**Our Case Number:** ACP-323606-25

**Re:** Proposed construction of 67 no. housing units  
on a site at Tyrells Land, situated along Stradbally Road, Portlaoise, Co Laois

Our Ref: C25-003 L2 - An Coimisiún Pleanála  
Reply to: 2 John St., Kilkenny, mail@boda.ie  
Date: 9<sup>th</sup> February 2026

**Re:** Tyrrell's Land, Stradbally Road, Portlaoise, Co. Laois Section 177AE  
**Re:** Case reference: ACP-323606-25  
**Client:** Christopher Fingleton and Mary Tyrrell, Portrane House, Stradbally Road, Portlaoise.

NORTH

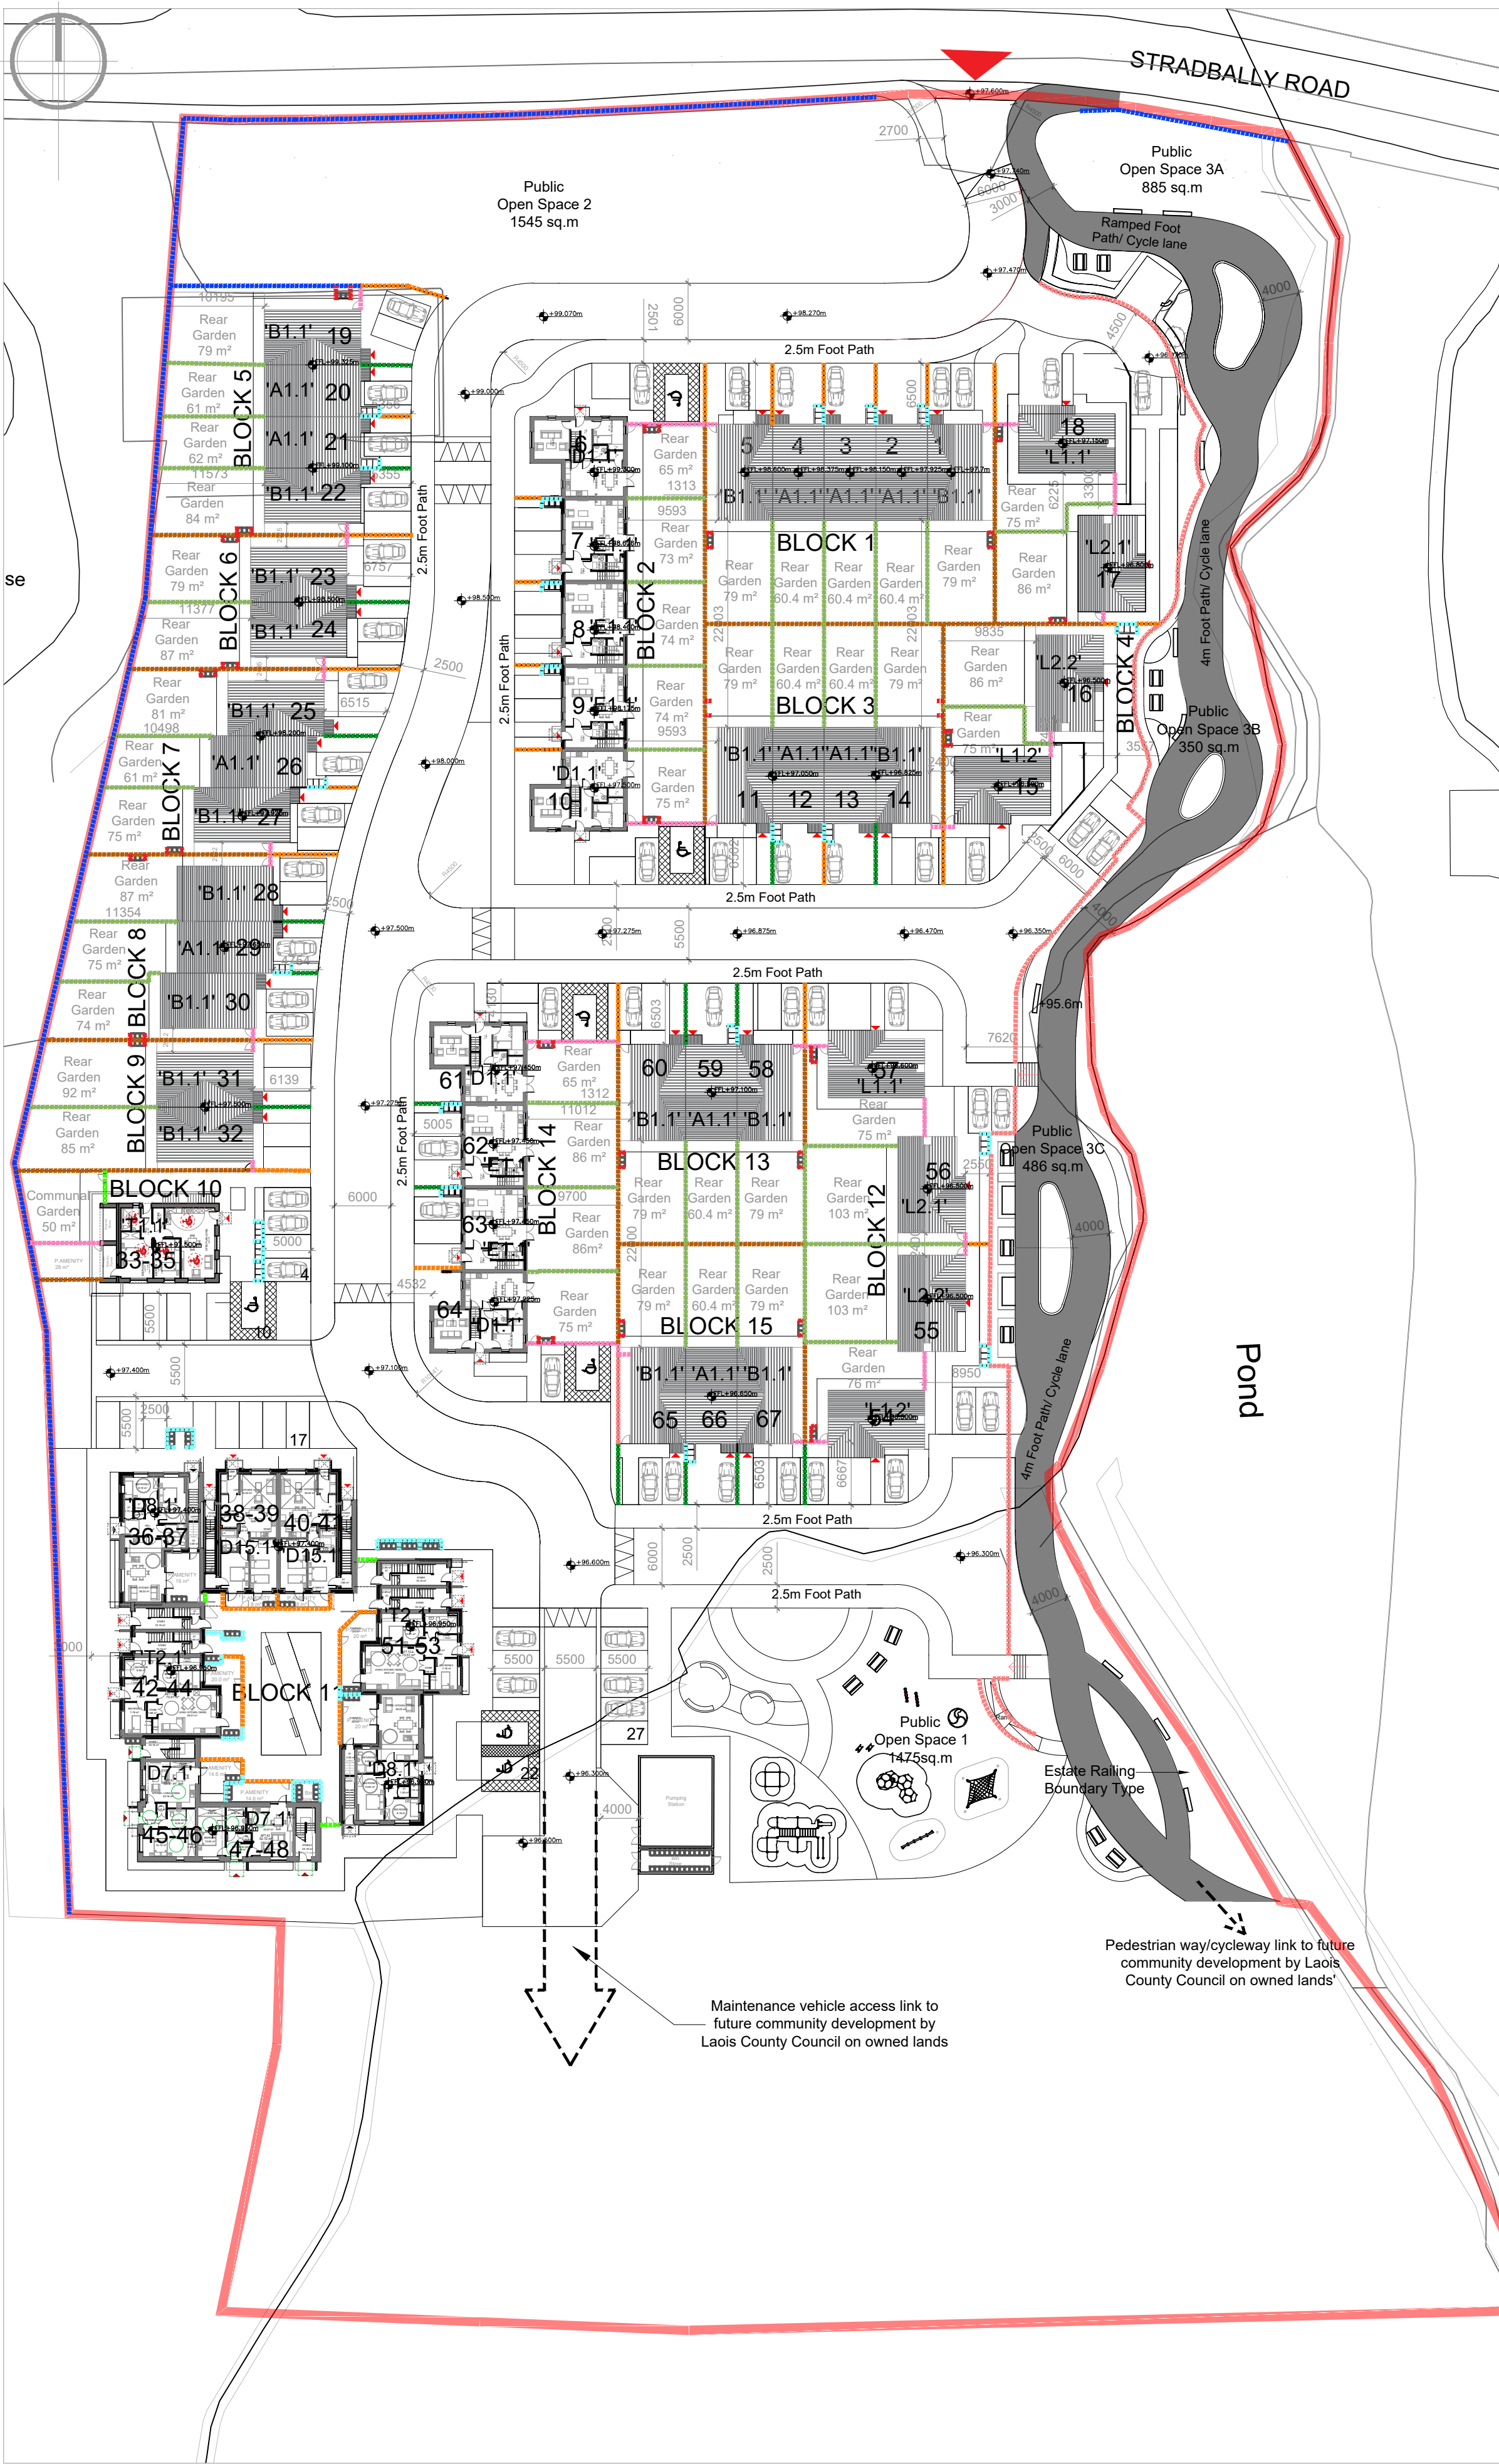
**Item 7** We also note the Council's comments regarding the boundary wall treatment.

***“ A 2m block wall with appropriate capped finish, landscape buffer, and native tree planting (already proposed) achieves: No adverse impact on heritage significance.”***

Please see Photo 1 from the Design Statement prepared by van Dijk Architects of the wall on the front boundary. This ties into the overall concept of the scheme. There is a requirement to respect the setting of the protected structure and where the vista is provided with an open space, the most appropriate wall finish would be stone masonry. This would be similar to the current setting walls as noted in the design statement.
